Application No: LU/93/25/PL
Site Address: Units 5-7 Watersmead Business Park Norway Lane/Worthing Road Littlehampton BN17 6LS
Description of works: Part demolition, conversion, refurbishment and re-elevation of Units 5 and 6 and construction of retail (food and non-food), leisure and food & beverage units (Use Class E), together with associated car parking, access, loading areas, landscaping and associated works. This application is in CIL Zone 2 and is CIL Liable.

This application was considered by the Littlehampton Town Council's Planning and Transportation Committee on Monday 16 June 2025. The committee did not object to the application, an extract of the minutes of the meeting is set out below:

21.3. Planning Application Reference LU/93/25/PL - Units 5 to 7, Watersmead Business Park, Littlehampton

title
**PROPOSED HIGHWAY IMPROVEMENTS
AND SITE ACCESS ARRANGEMENT**

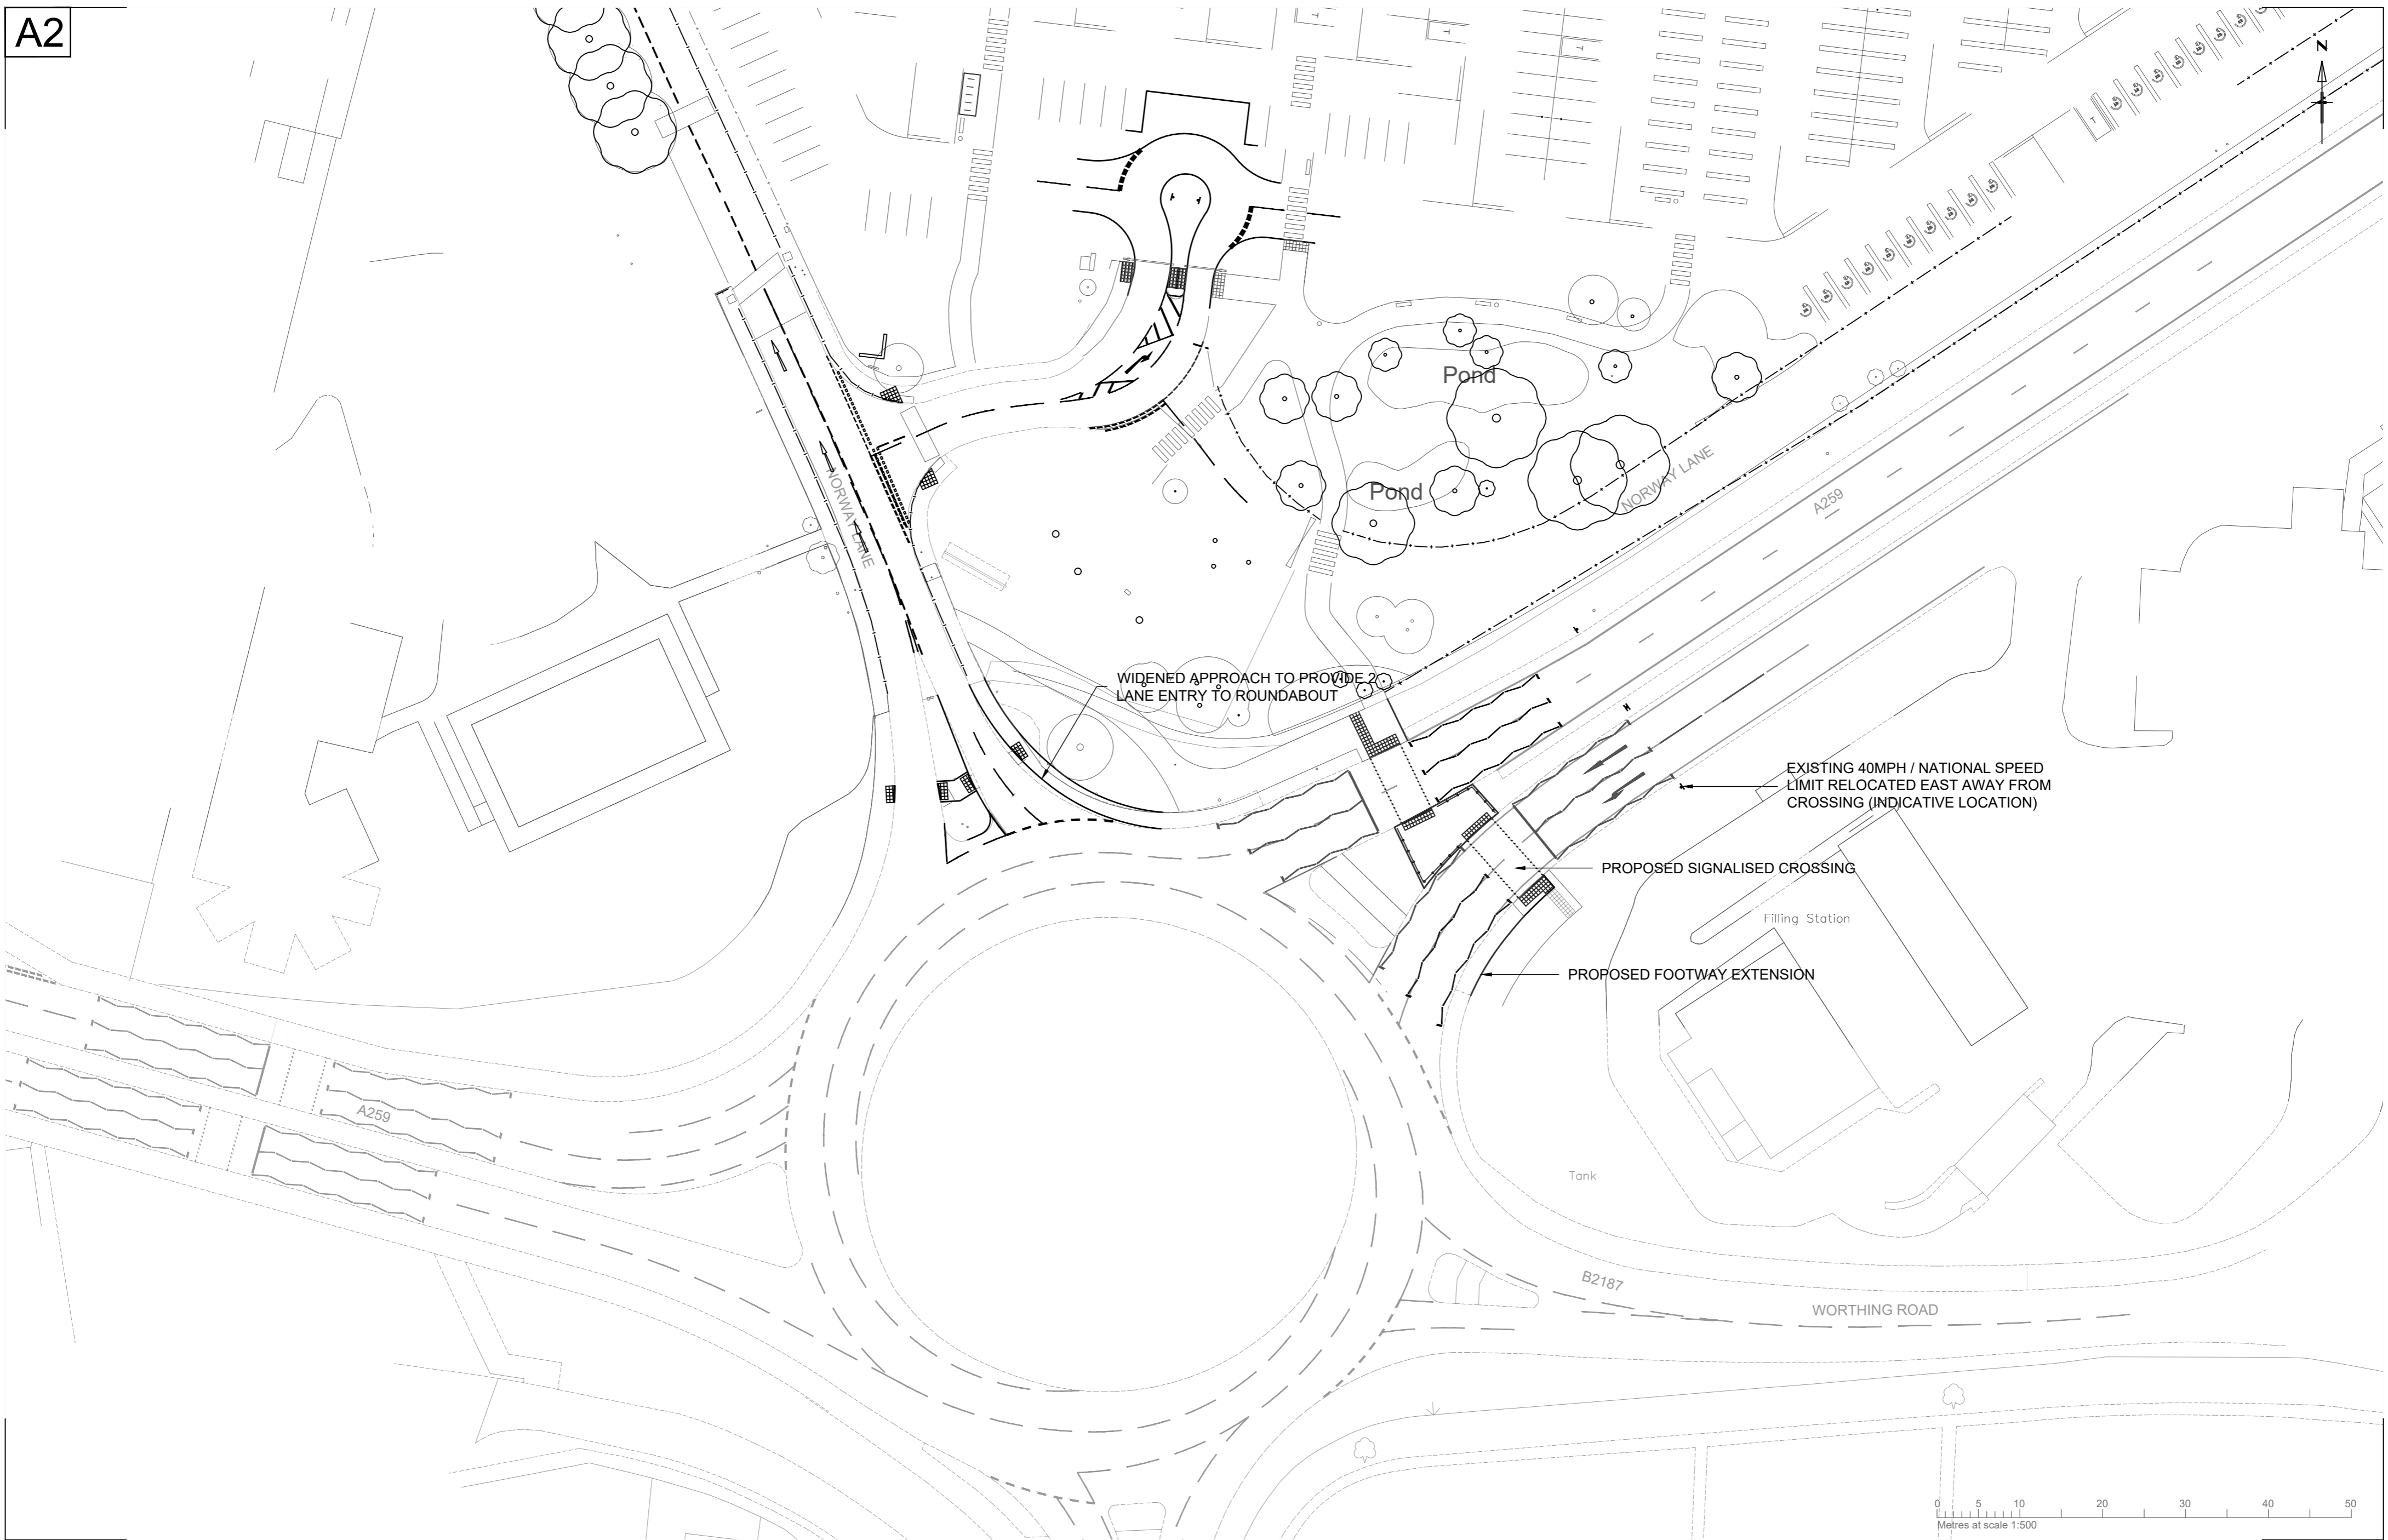
21.3.2. The application included a plan to introduce a signalised pedestrian crossing on the A259 eastern arm of the Body Shop Roundabout. The committee questioned this aspect of the scheme which was considered unnecessary when viewed in the context of the recent dualling of the A259 and the new pedestrian crossing on the western arm of the roundabout. In addition, the committee felt the introduction of a new crossing would cause congestion and increase pollution. It was also hoped that local bus services

would be encouraged to stop at the site which would improve connectivity.
